7 September 2018

**Modification request to modify State Significant Development 6074 for the Norwest Private Hospital Expansion at 7-11 Norbrik Drive Bella Vista**

I refer to your request to respond to traffic and parking issues raised by various authorities with regard to the above proposal. My advice is as follows.

Figure 5. Parking survey locations (on-street).

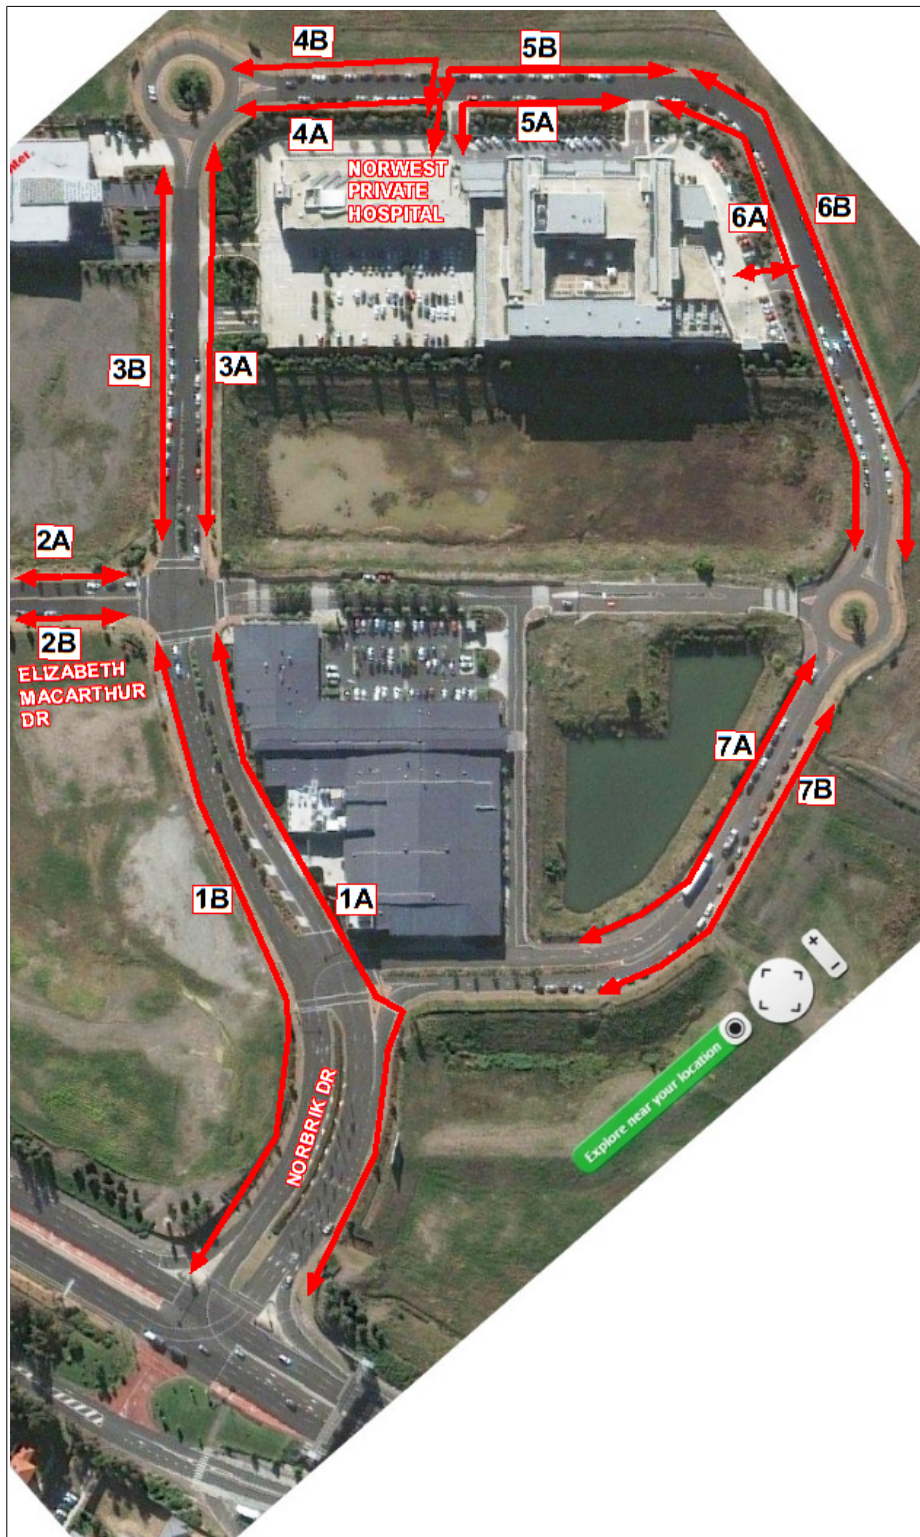
- Whilst no objection is raised with regard to car parking, it should be noted that a temporary car park to the north of the hospital on Norbrik Drive (Lot 6053 DP 1140054) was approved on 7 August 2015 under Development Consent No. 31/2016/HA for use by hospital staff during the hospital expansion. In addition, a Section 96(1A) modification was granted on 11 April 2017 to extend the temporary land use for a further 24 months and permit the use of the car park of the general public under a paid parking scheme. Confirmation should be sought that the car parking spaces approved for this temporary land use has not been included as "vacant car parking spaces" in the justification for the shortfall for the subject application.

I confirm that in consideration of the modification proposal our calculations of the existing and proposed car parking demand and provision included only previously approved car parking spaces on site and did not include the temporary car park to the north of the hospital (refer to a Figure from the TEF report reproduced below). In consideration of general parking availability around the hospital, TEF Consulting conducted on-street car parking surveys. These surveys also excluded the temporary car park to the north, as evident from the survey map reproduced below.
